Attachment A – Response to Submissions

1. Traffic and Parking	
Comments from DoPE dated 2 June 2016	Proponent Response
<p>Required: an updated assessment providing:</p> <ul style="list-style-type: none"> The expected cumulative peak traffic and parking demand that includes the Sumatran Tiger Adventure project and the proposed Taronga Institute of Science and Learning Additional traffic and parking demand from additional day visitor patronage from the proposal in its entirety Impact on traffic and parking demand when Taronga Zoo host night-time events Clarify that on-site parking would be part of guests' package and detail arrangements for guests arriving via other forms of transport Discuss measures to prevent zoo visitors parking on streets surrounding the zoo. 	<p>Please refer to Attachment F which includes a revised Transport Impact Assessment that assesses the expected cumulative peak traffic and parking demand and measures to prevent zoo visitors from parking on streets surrounding the zoo.</p> <p>On-site parking will be included as part of a guests' booking at the Taronga Zoo Eco-Retreat.</p>

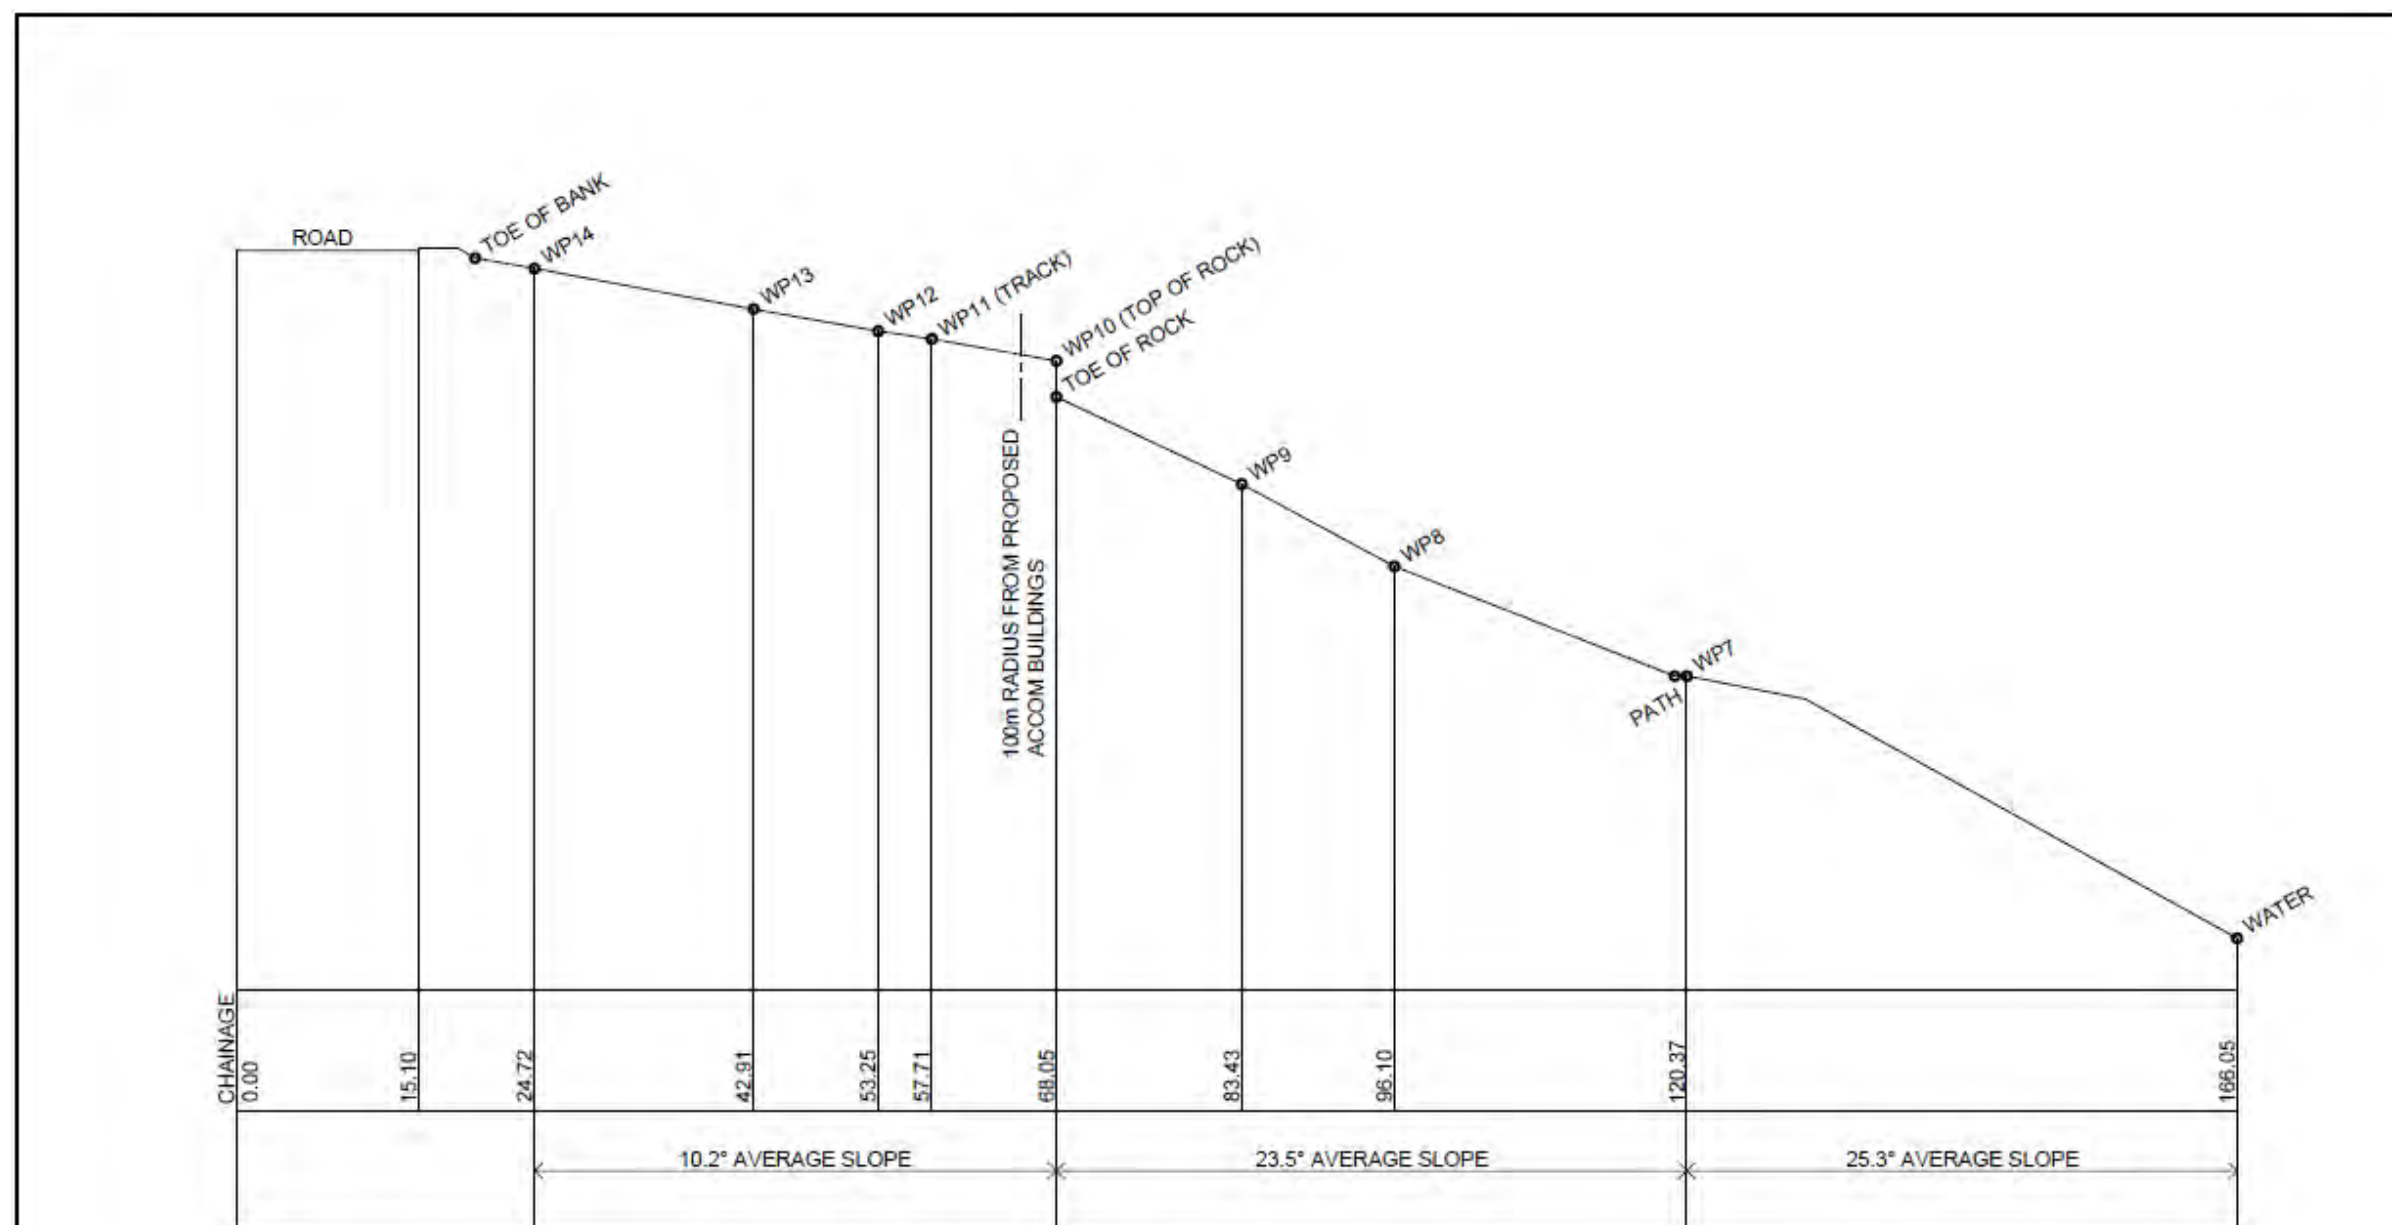
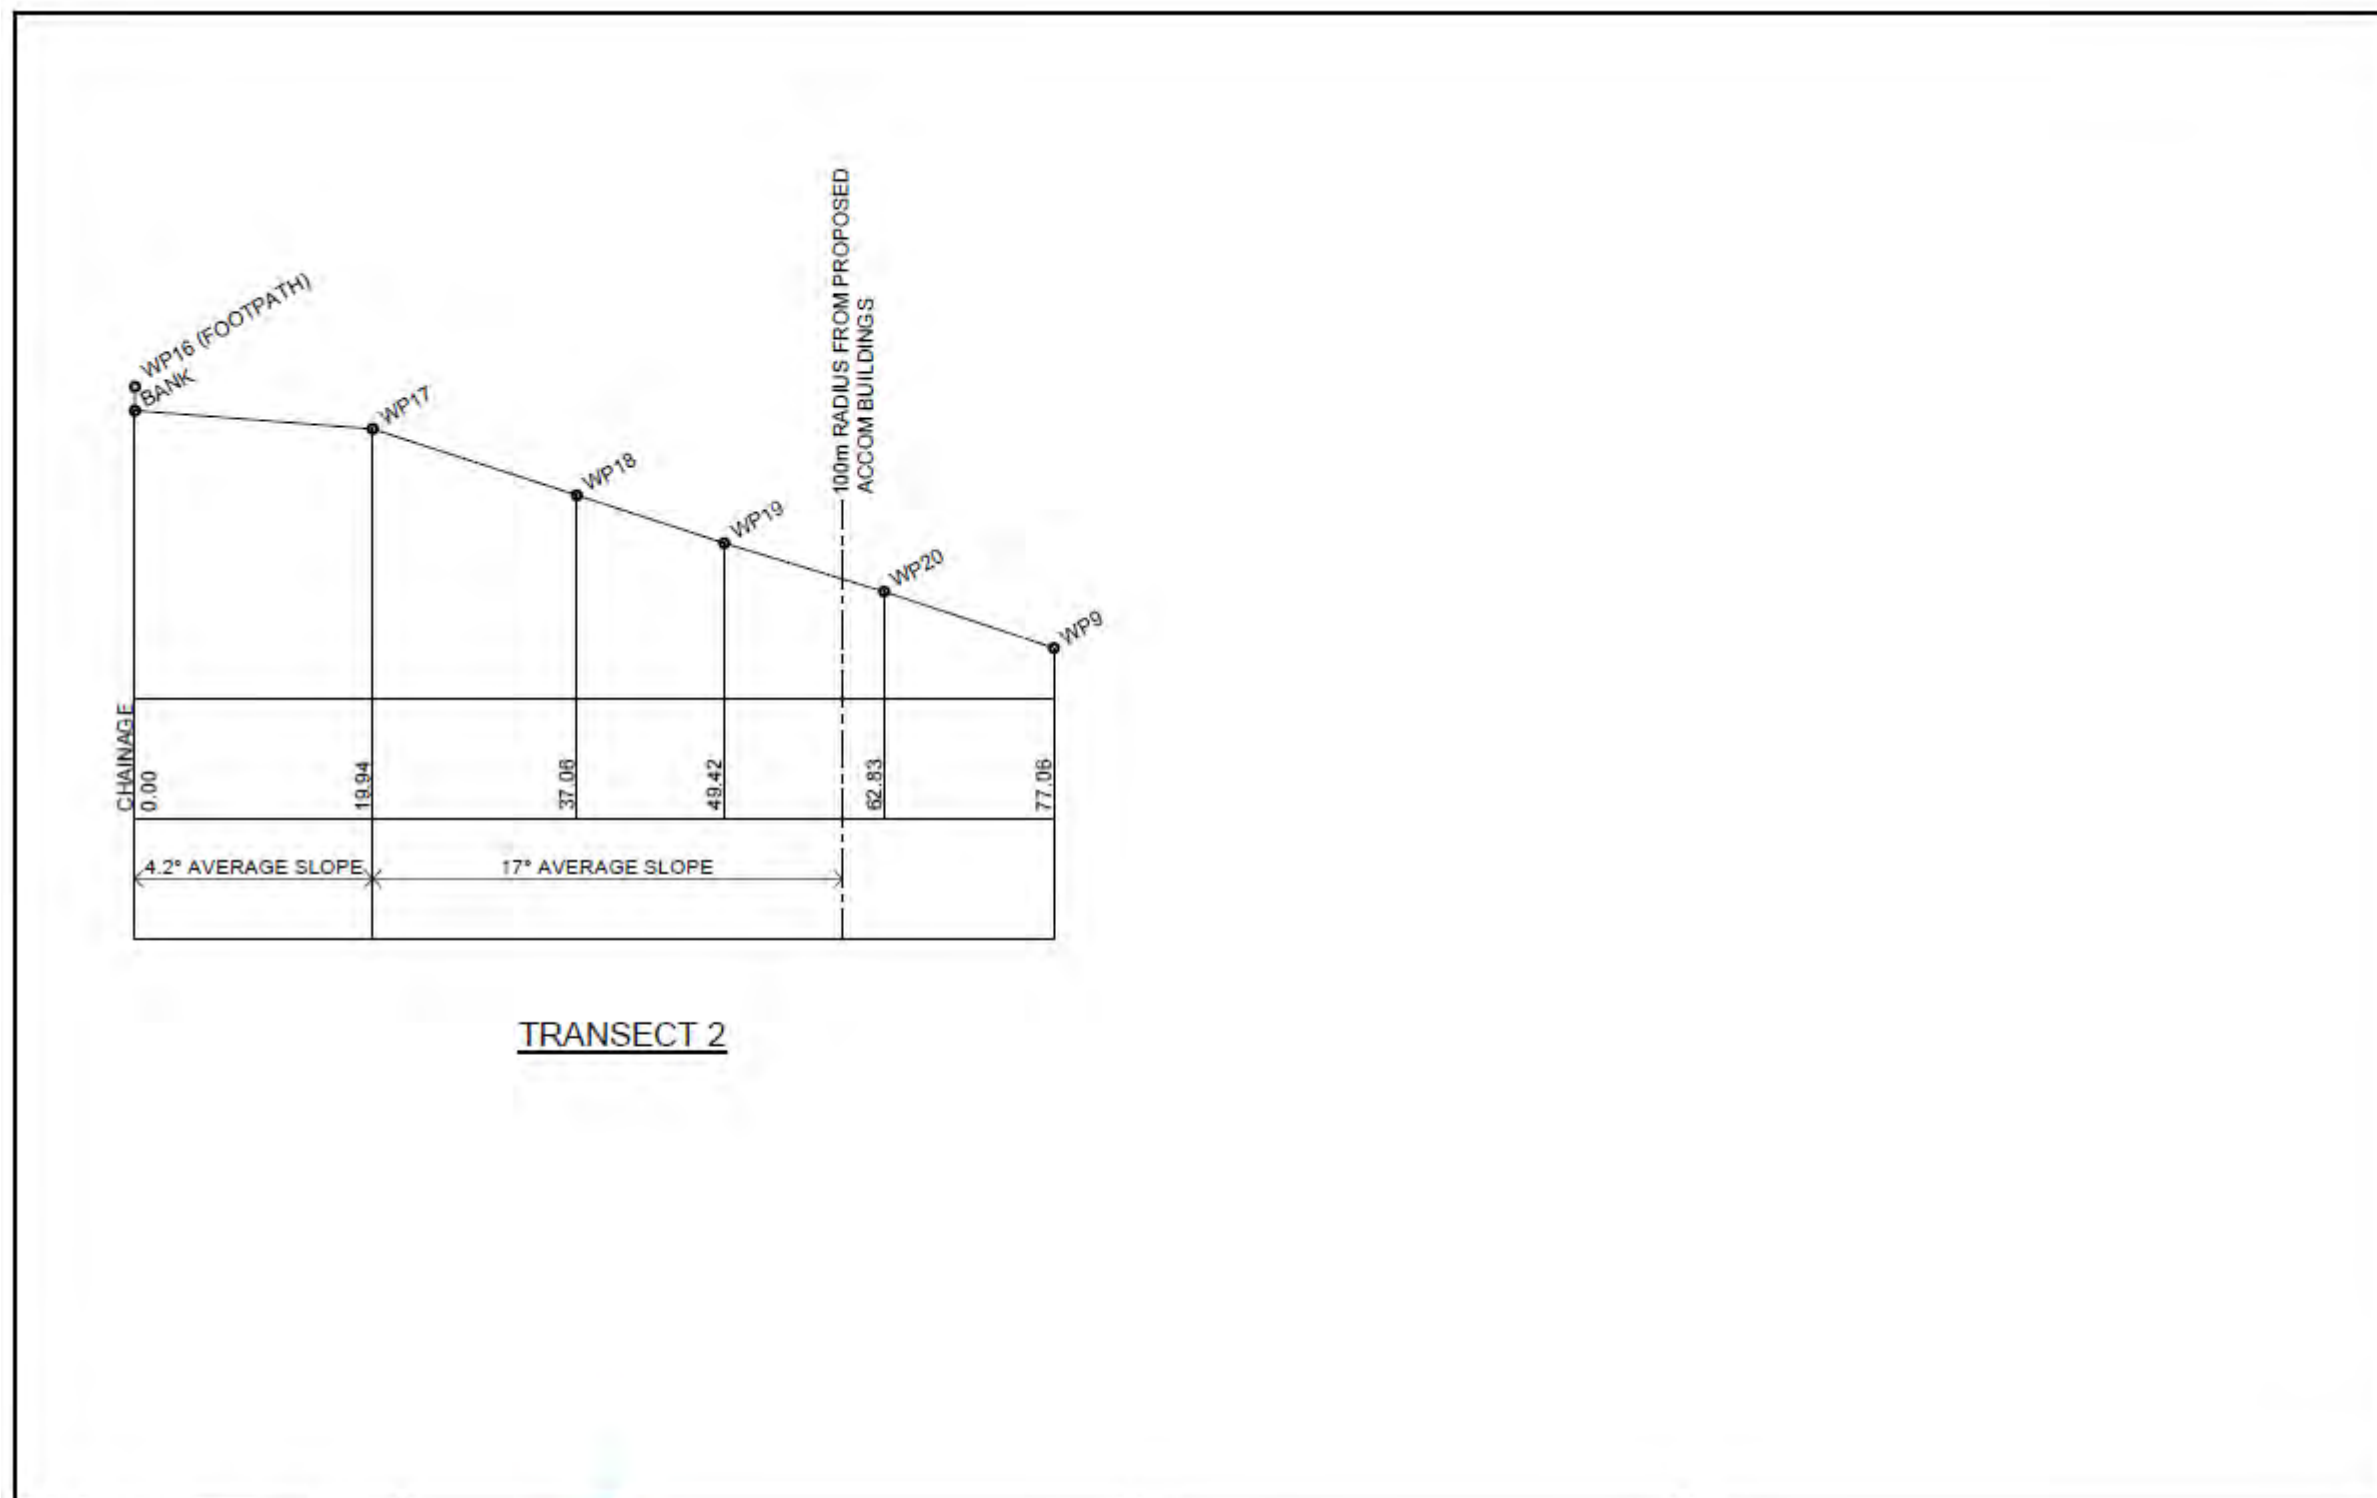
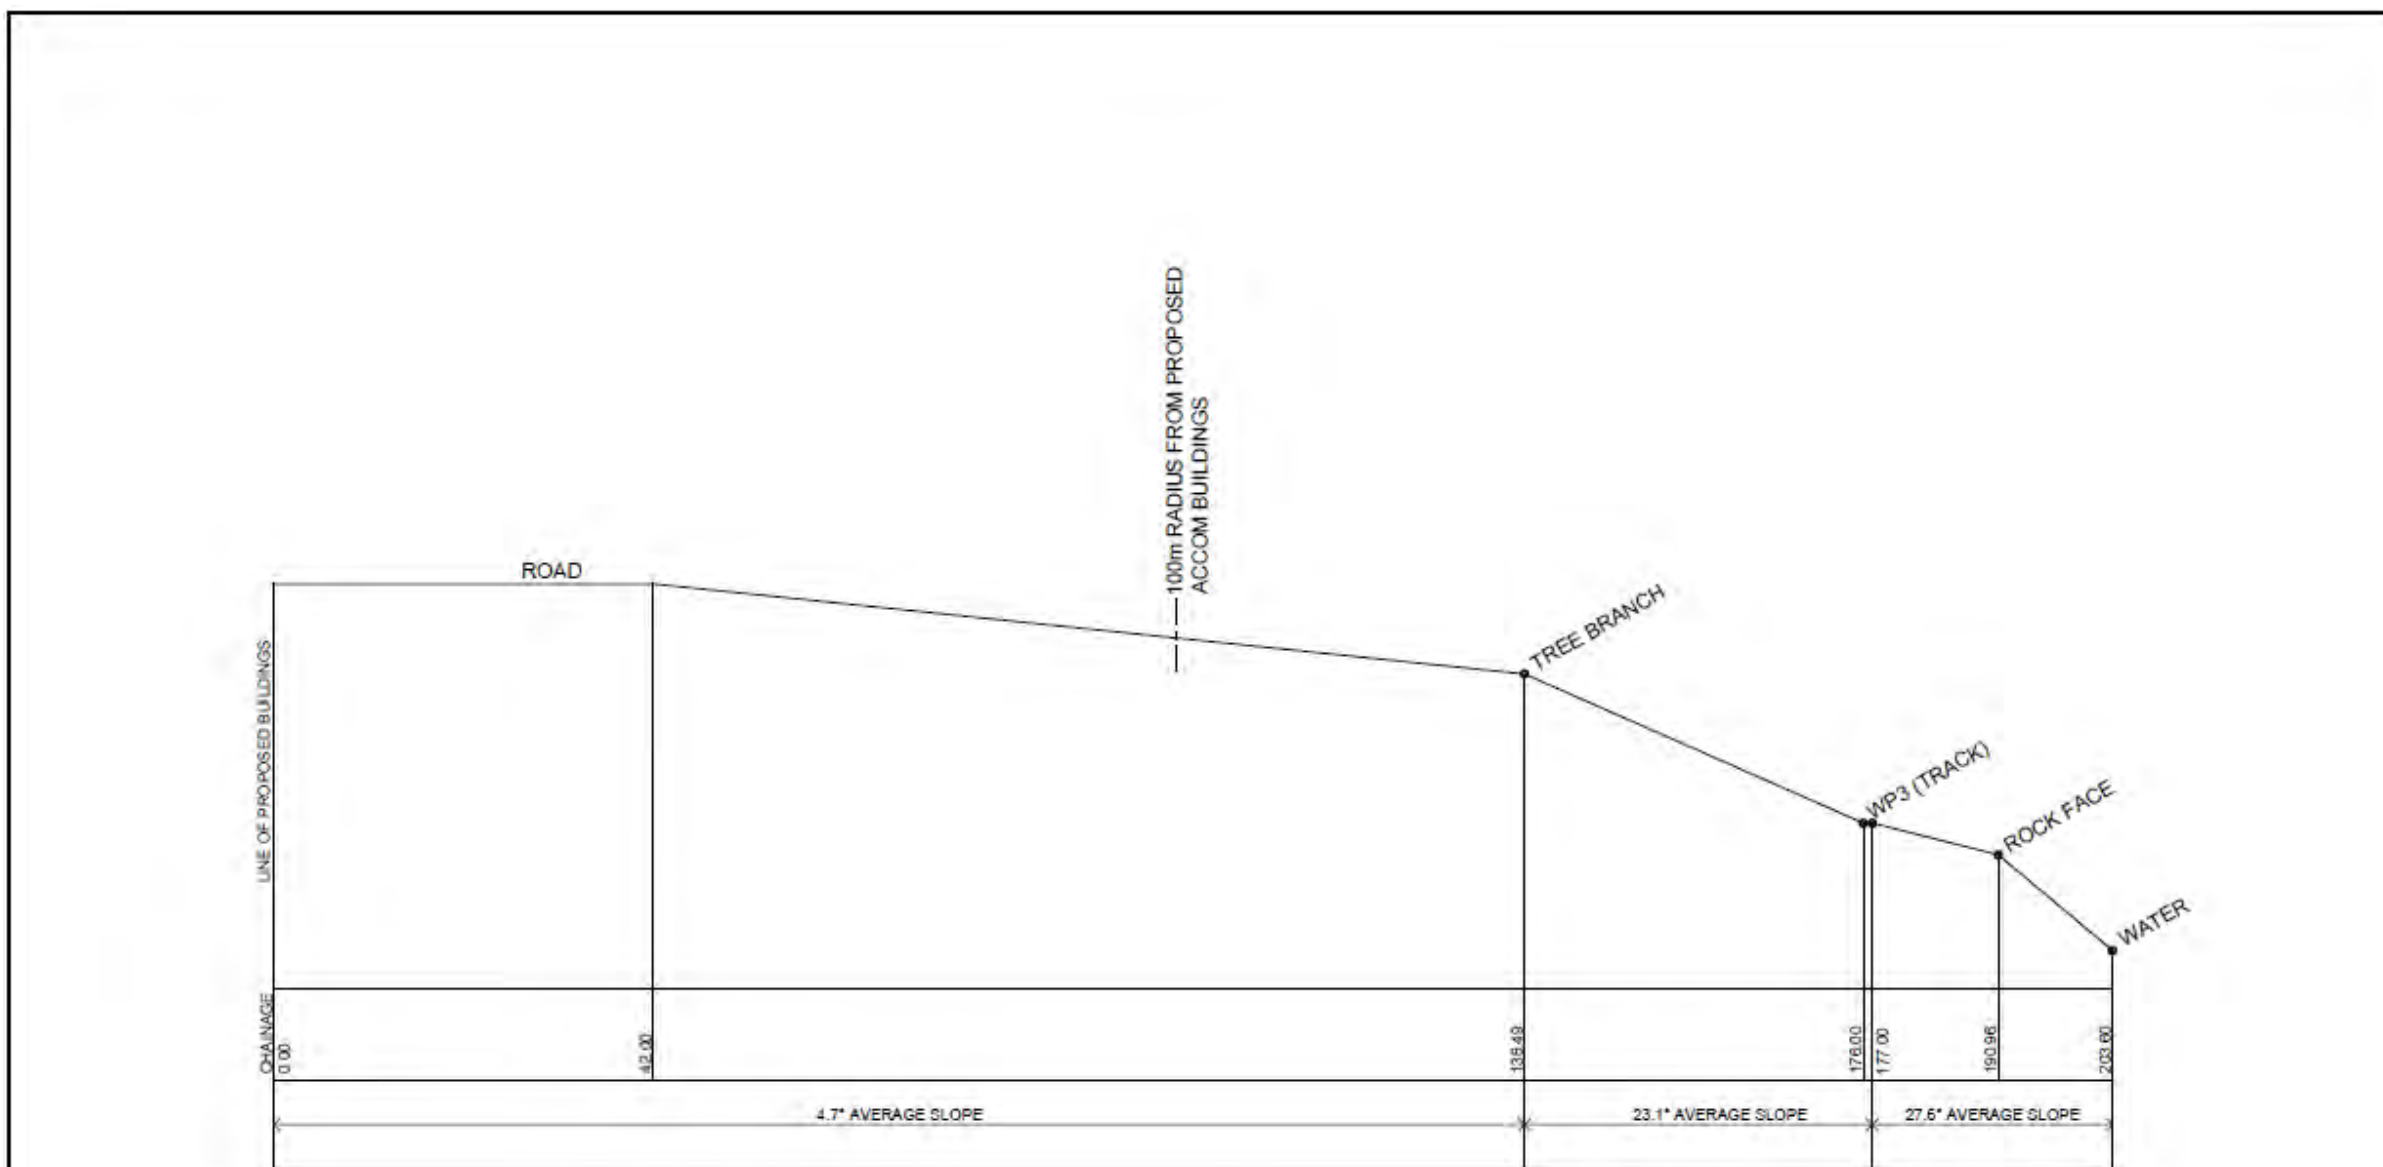
11. Bushfire Safety	
Comments from public submissions	Proponent Response
11.1 Taronga Zoo is on Enclosed Lands and therefore poses serious potential risks and the fire brigades getting access to the area, thereby seriously jeopardising all neighbouring owners properties to potential fire hazards.	The concern has been noted and has been addressed by the Bushfire Safety consultant as part of the EIS.
